DELEGATED DECISION TO DETERMINE PLANNING APPLICATIONS

Reference No:	2026/62/92192/W
Site Address:	57, Adelphi Road, Marsh, Huddersfield, HD3 4BB
Description:	Change of use of residential dwelling (Use Class C3) to children's home accommodating one child (Use Class C2)
Recommending Officer:	Joshua Merriman

Officer Report – 2026/92192

Project Title
existing and proposed floor plans

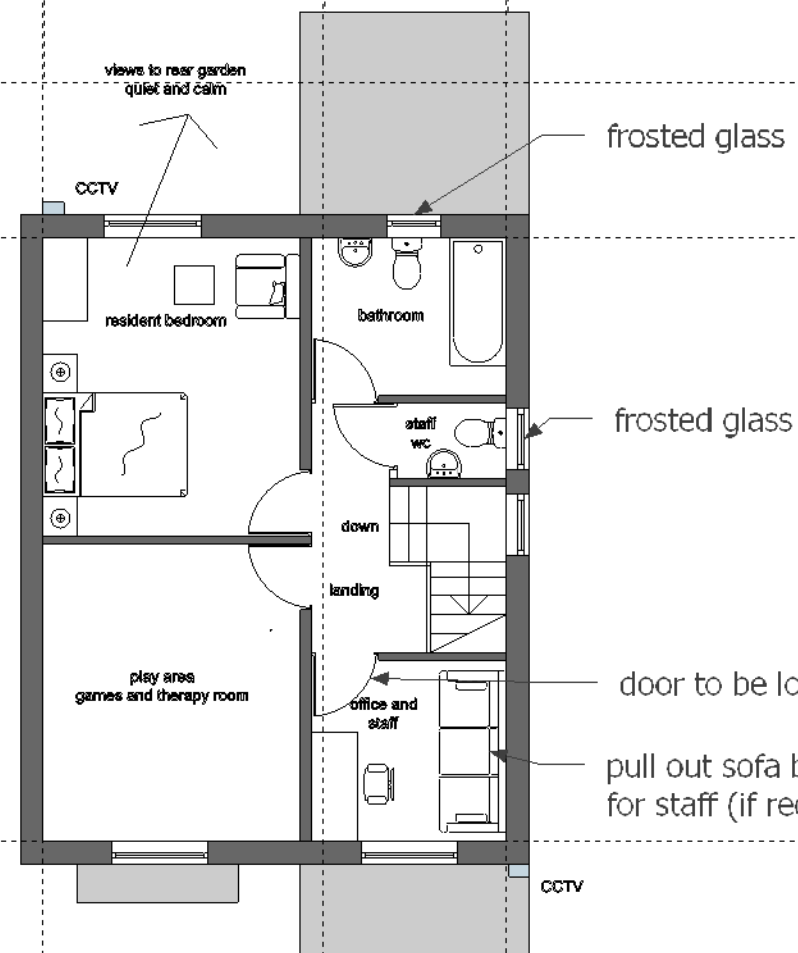
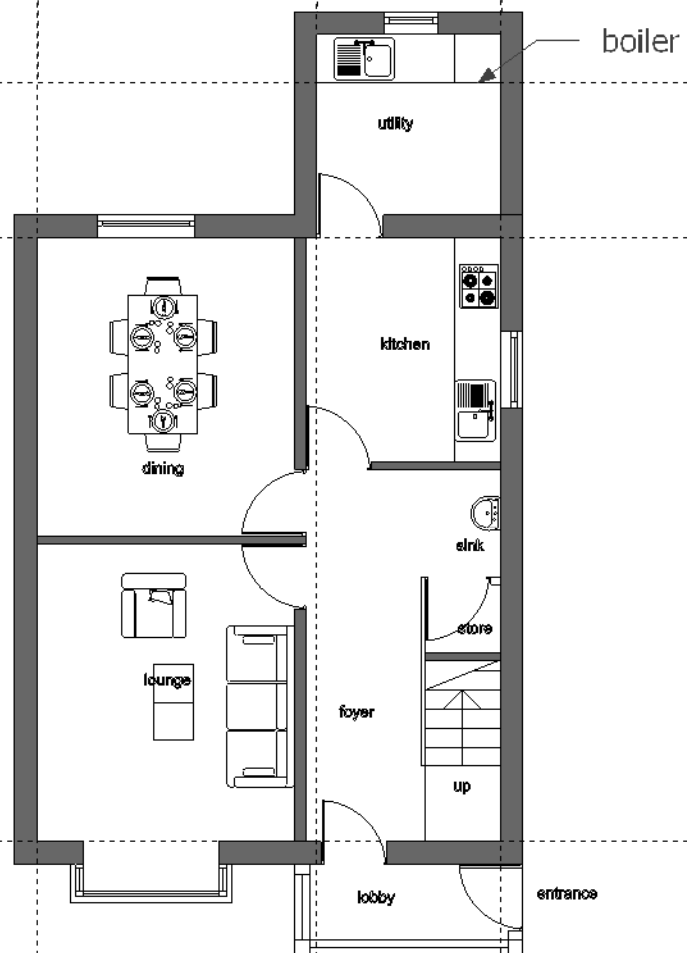
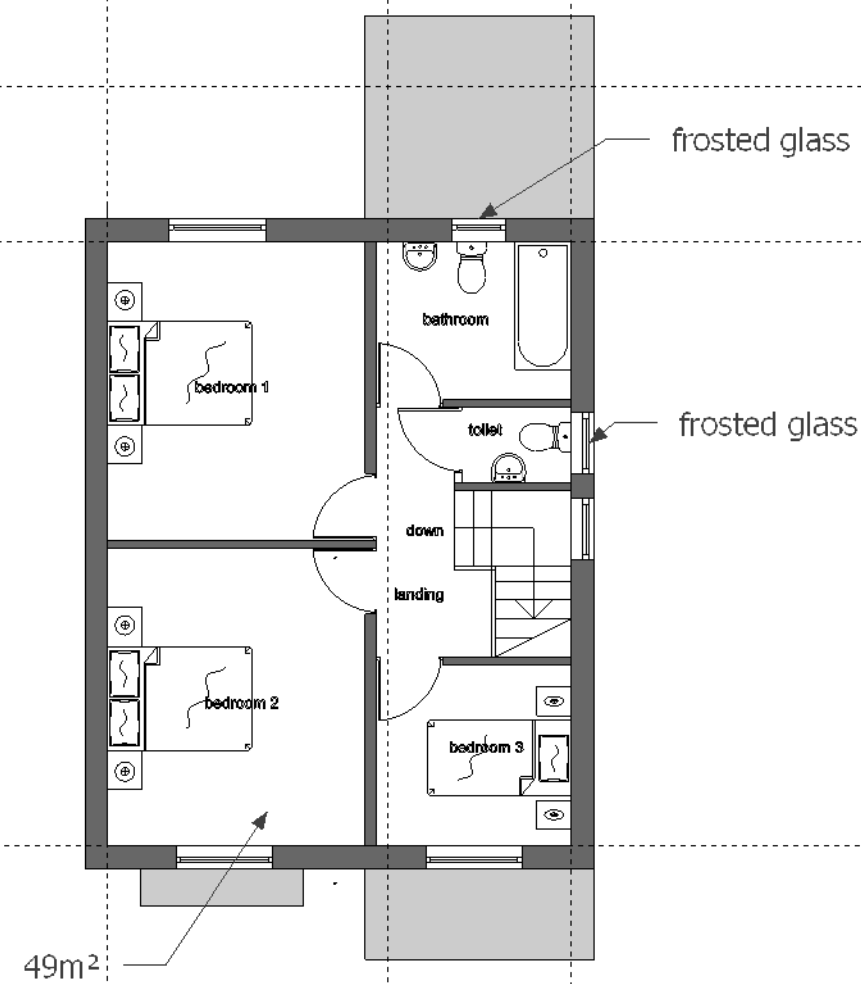
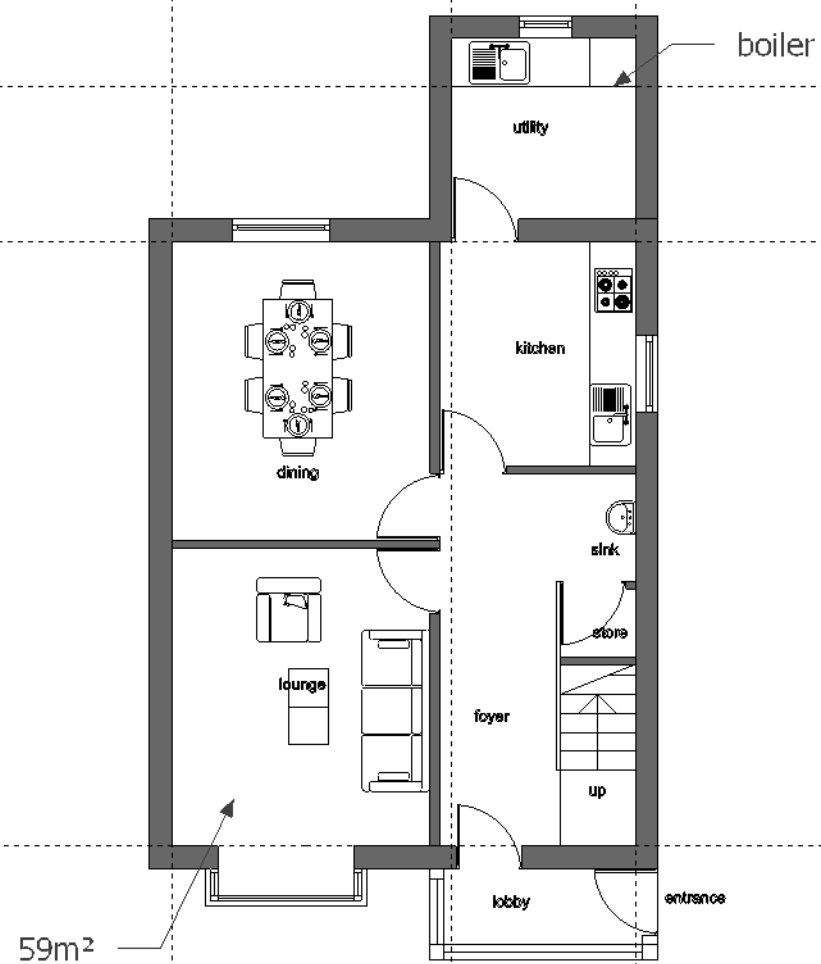
- The outdoor garden or indoor communal space may be mathematically insufficient to meet both the recreational needs of the residents and the privacy buffers required for next-door neighbours.

Officer Comment: There is considered to be significant space inside the property to comply with NDSS standards, as well as ample amenity space serving the application property, with the use of the dwelling not being considered significantly different to a family home which would have the same impact upon neighbouring occupants utilising their private amenity space.

Project Title
proposed site plan

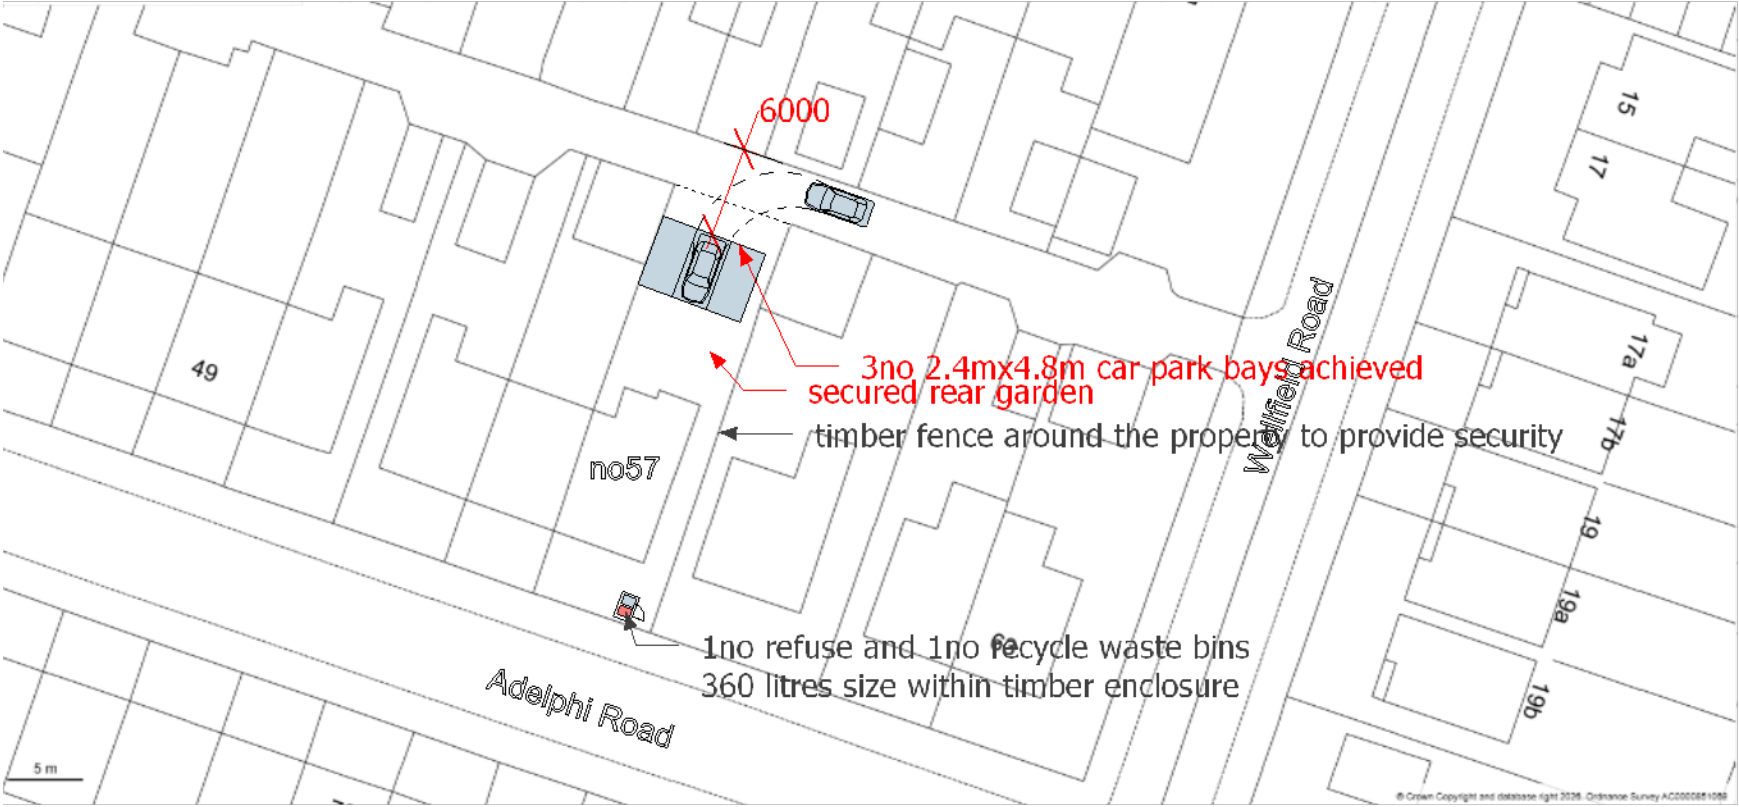
- The submitted Proposed Site/Block Layout drawing labels the rear yard, which is also shown as providing three car parking bays, as a 'secured rear garden' with a 'timber fence around the property to provide security.' This is a description of what the applicant proposes to install, not of the property's current condition: based on my own first-hand knowledge of the site, no such perimeter fencing or rear security currently exists. I supply photographic evidence of the site's current condition separately in support of this objection. As the safeguarding

case for this application appears to rely in part on this proposed security package, I would ask the Council to require the applicant to confirm precisely what boundary treatment and access control is to be installed, when, and how it would be reconciled with regular vehicle movements in and out of the parking area, and, if planning permission were to be granted, to secure this by way of a pre-occupation planning condition rather than accept it as already in place.

Officer Comment: The parking area to the rear of the site was requested as part of the previous application to ensure there would be no significant stress on existing on-street parking measures at the dwelling. This parking area to the rear of the site has previously been considered acceptable by KC Highways Development Management and thus continues to remain as acceptable for the number of staff and vehicles proposed to visit the property.
